Our Ref: R/2025/16/A
File No: 2026/041860
Your Ref: SSD-75493483

Advice on RTS – Forest Lodge Integrated Seniors Living – SSD-75493483

Thank you for your correspondence dated 28 January 2026 inviting the City of Sydney Council (the City) to comment on the Response to Submissions (RTS) package for the above proposed development.

TITLE OSD PLAN AND SECTIONS	
PROJECT No. S24129	DRAWING No. CI-0350
REV C

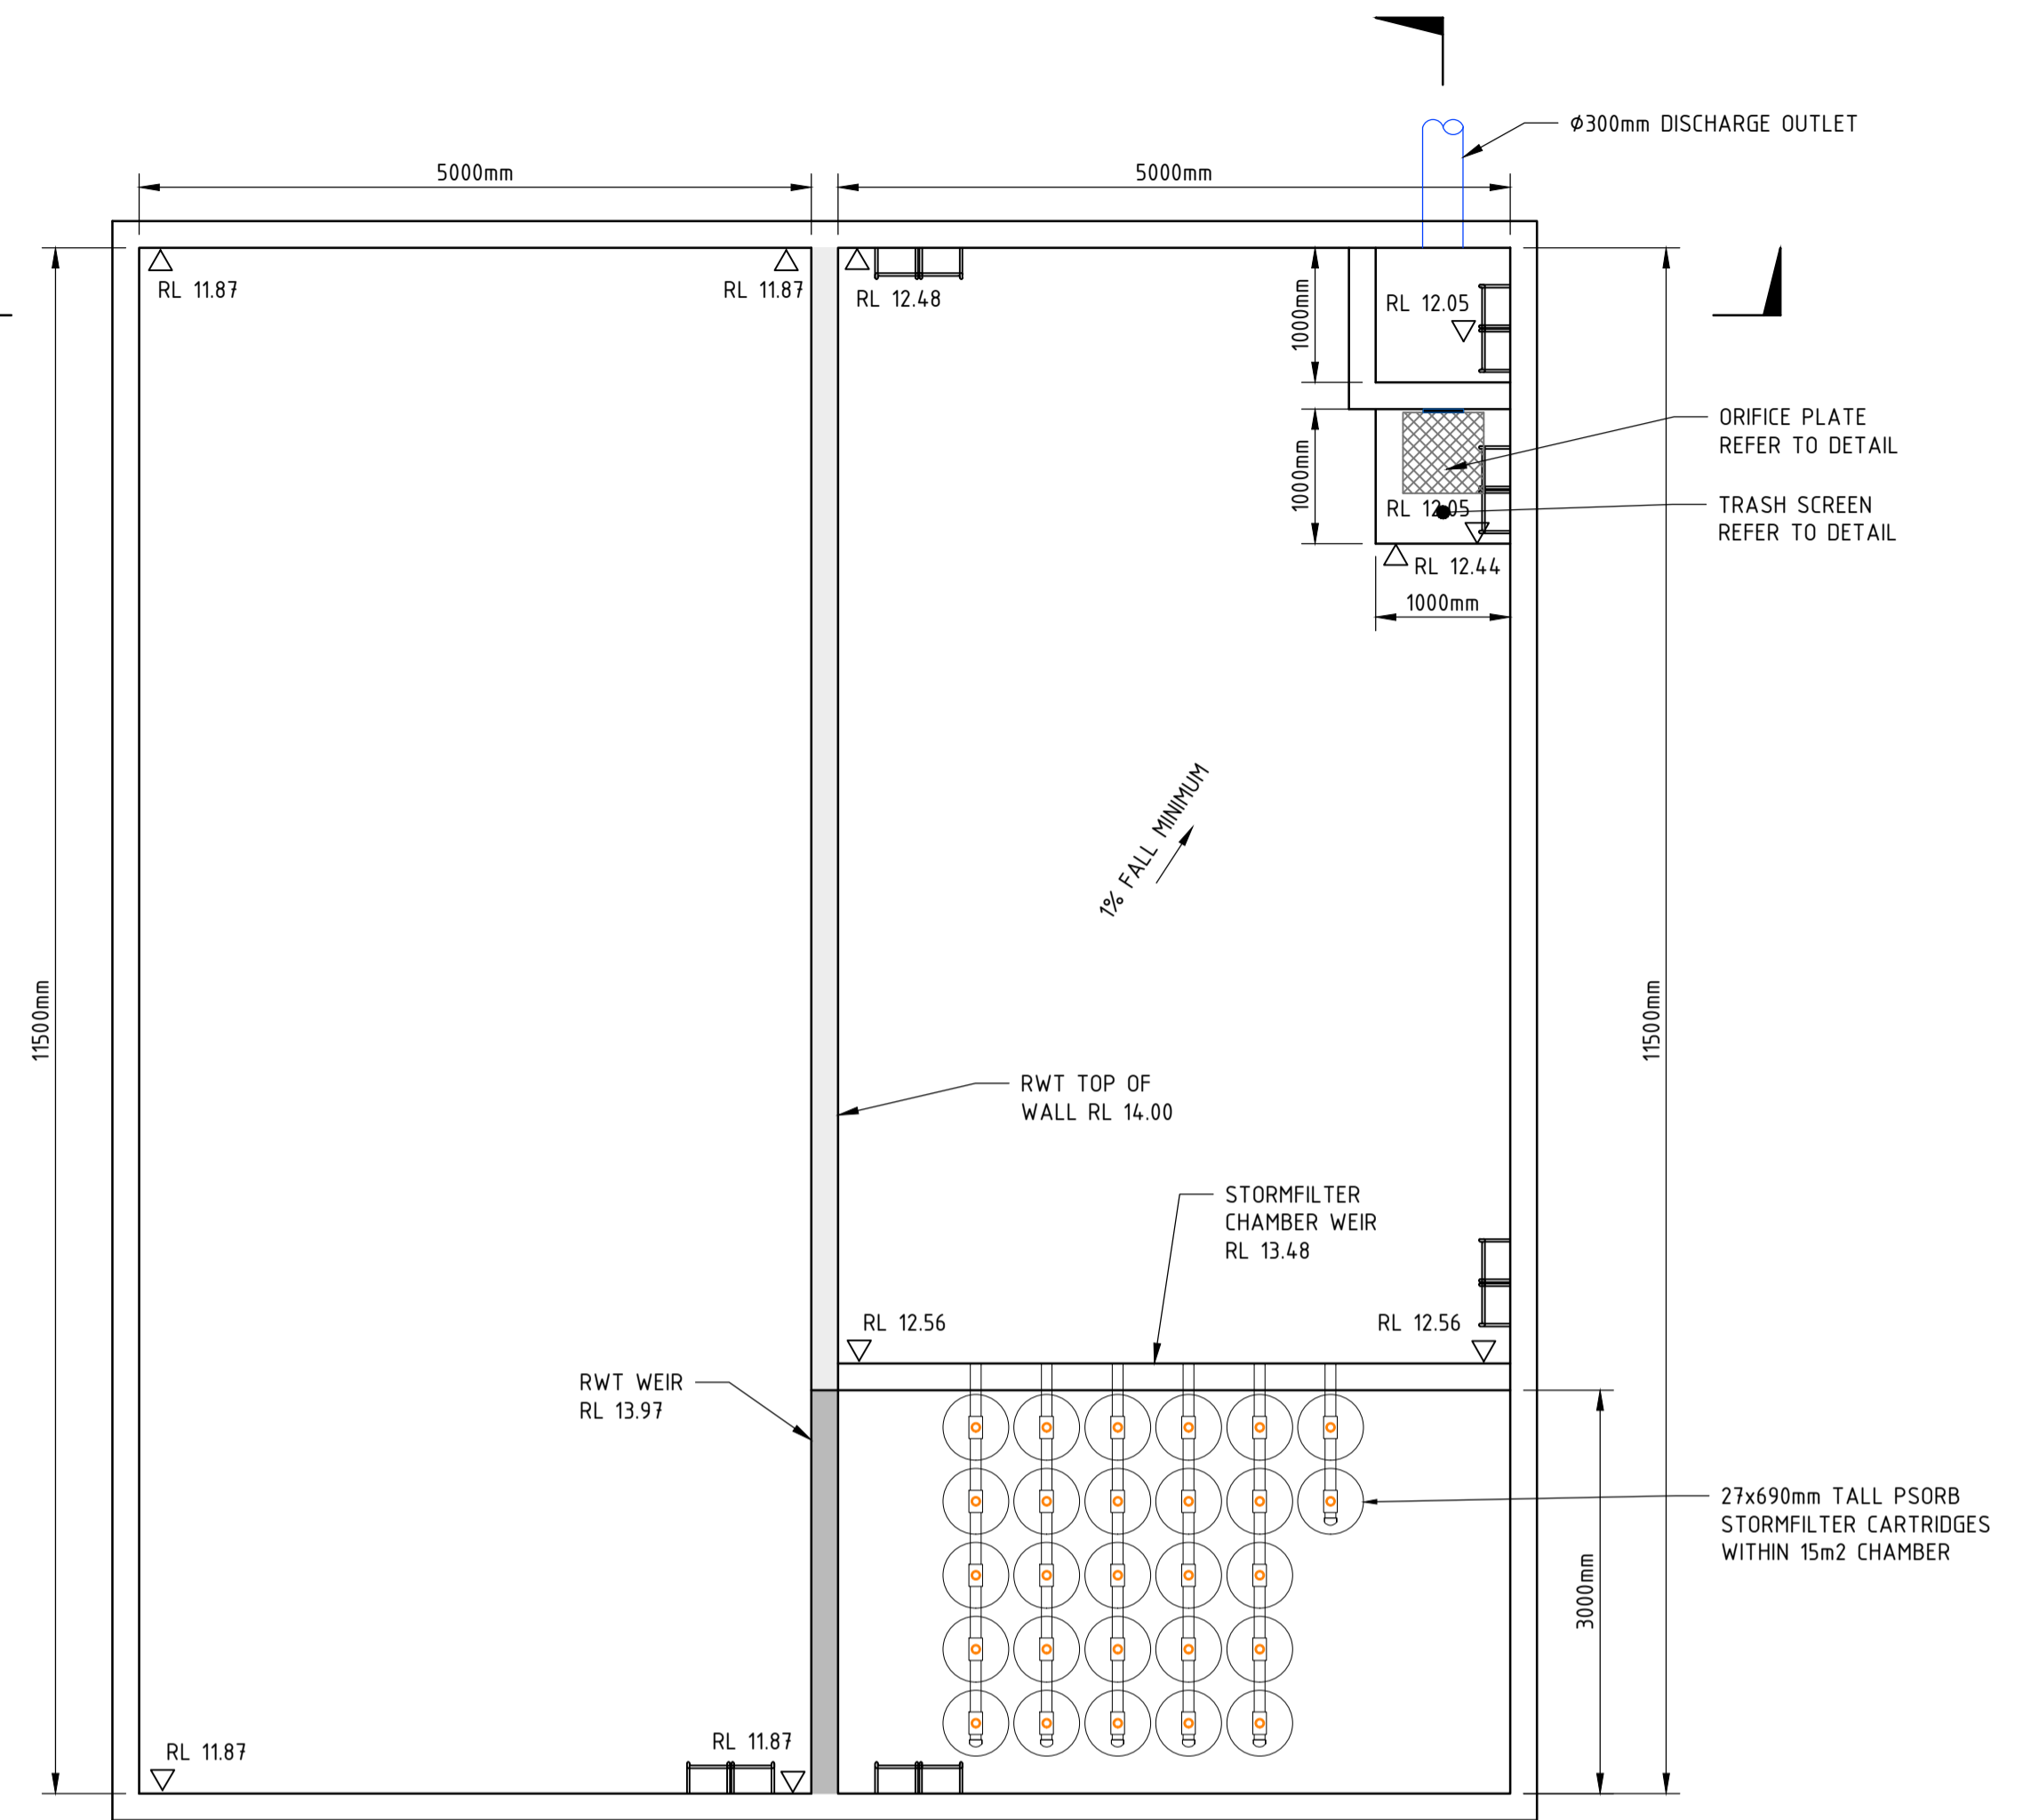
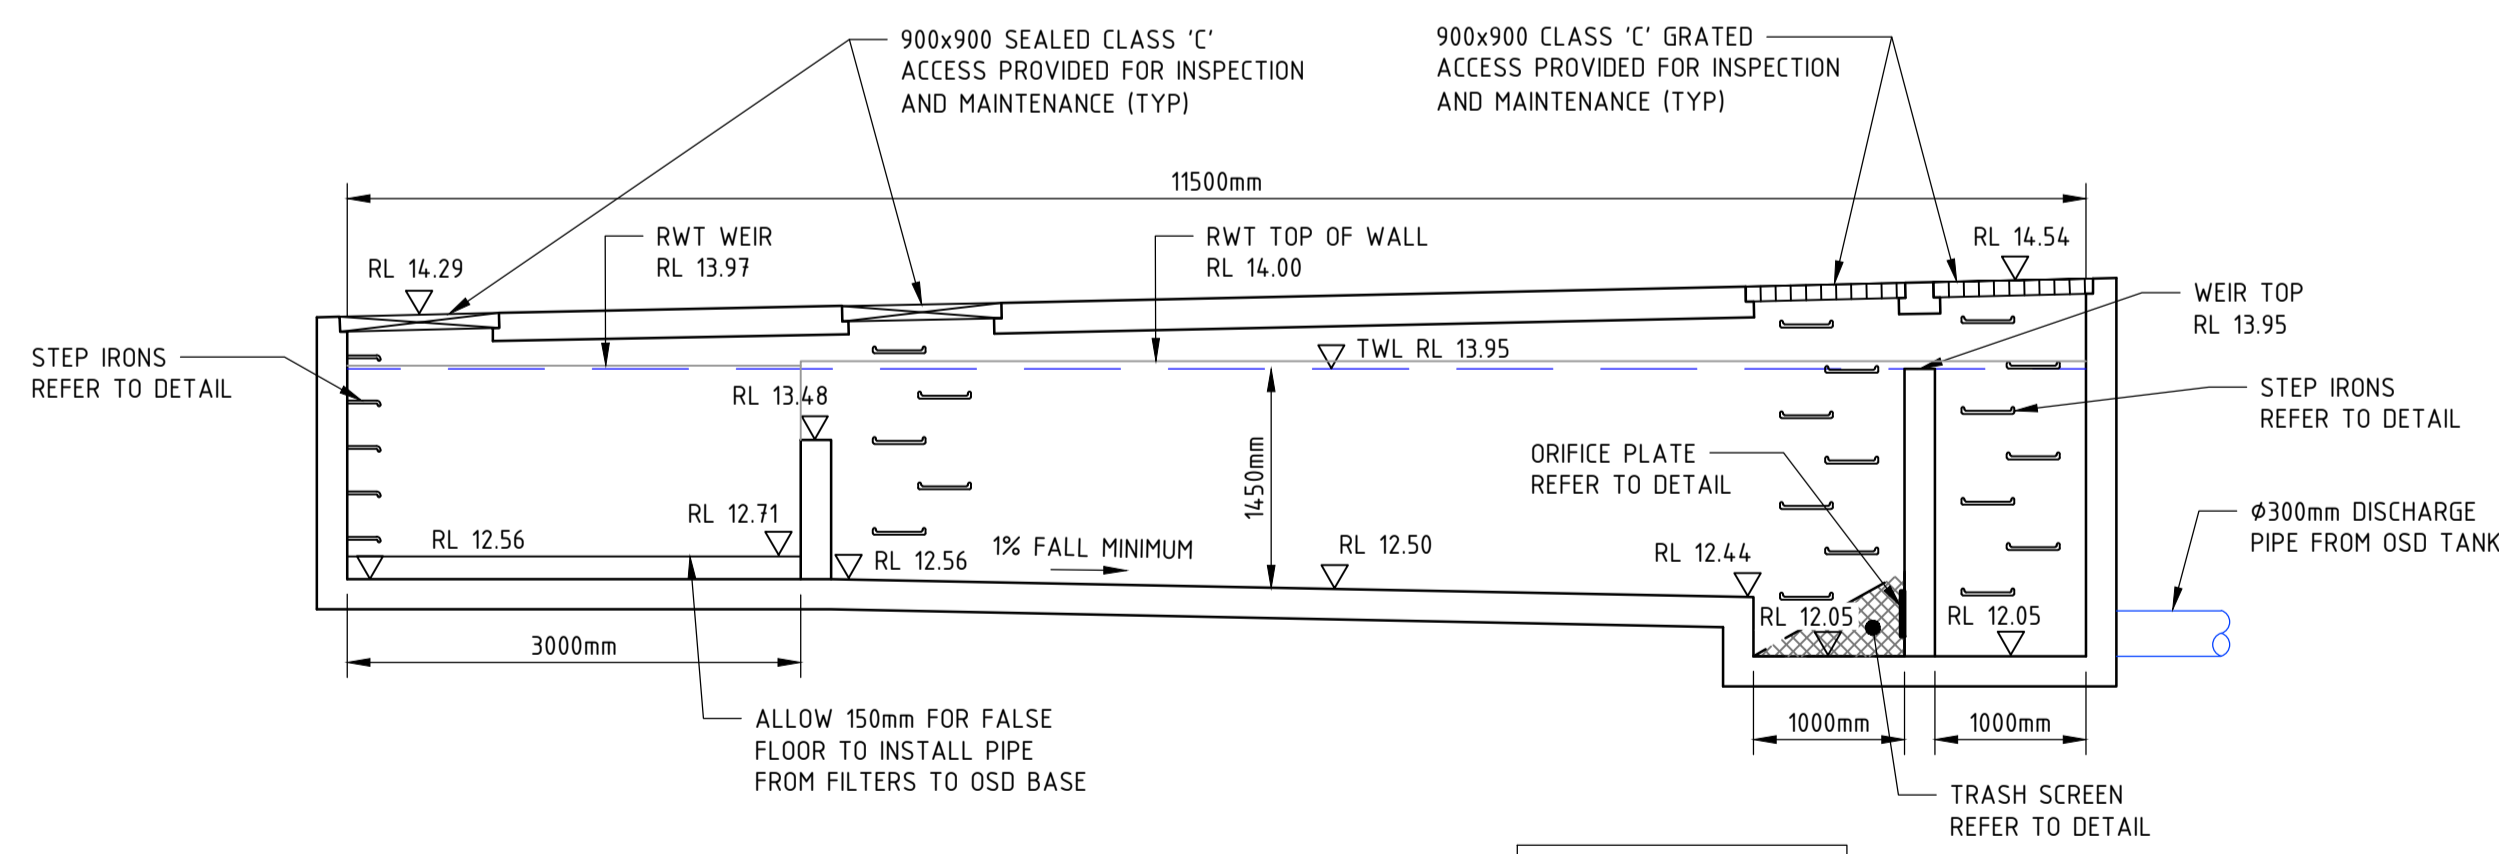
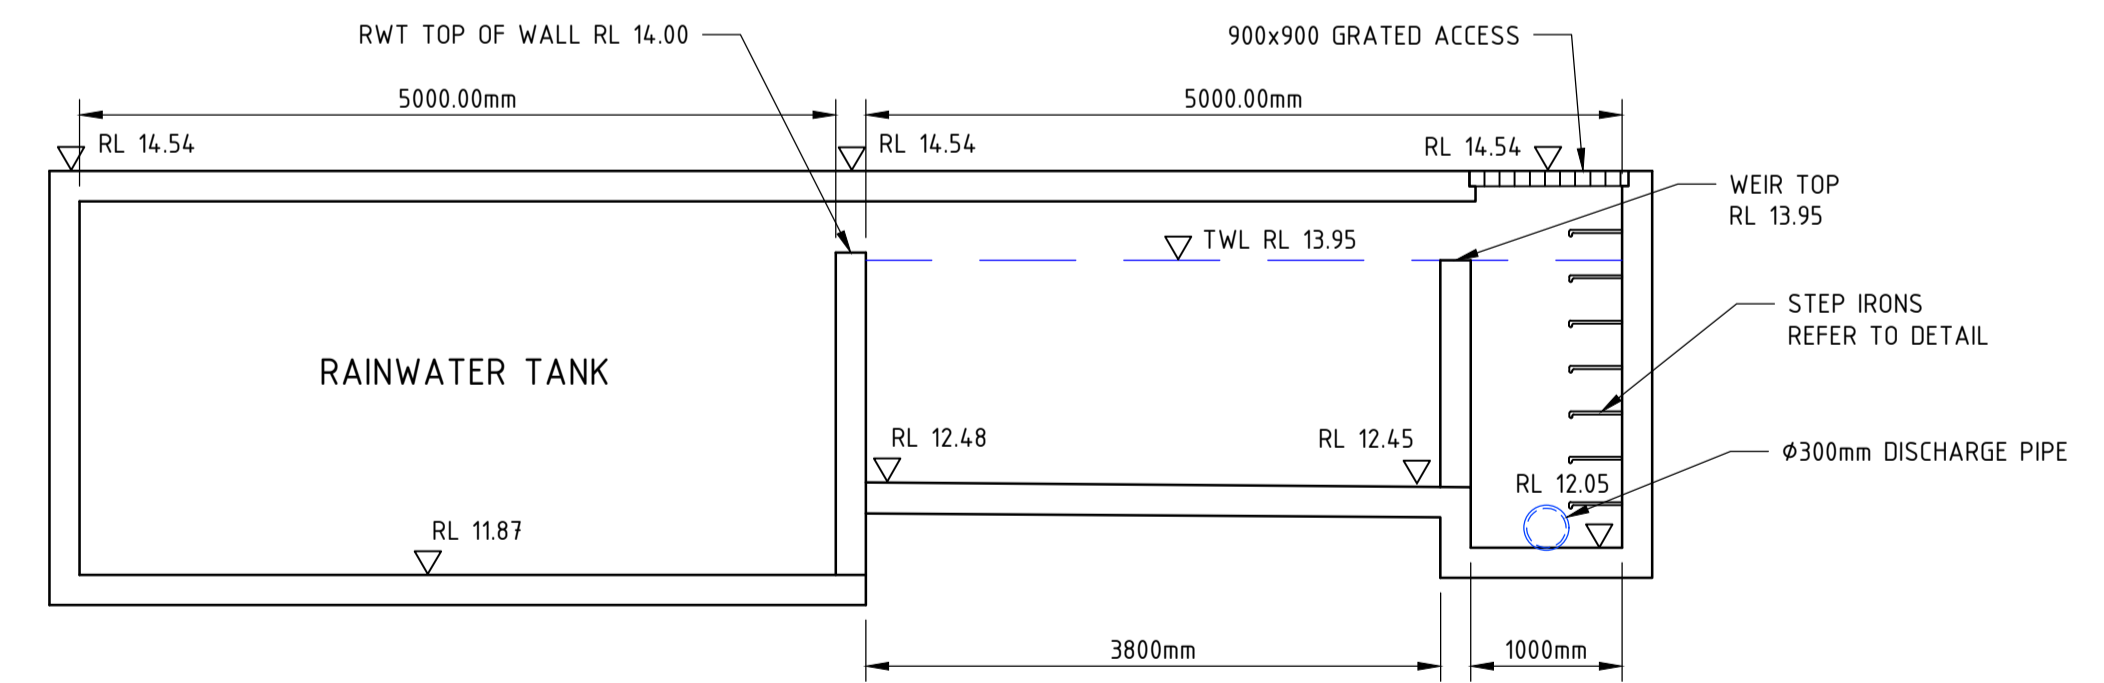
There are also concerns with the location and position of the OSD tank, including whether it will be inundated during types of flood events and whether it can effectively function or reduce downstream flows if located below the relevant flood planning level. A certificate and/or report generated from MUSIC link, together with
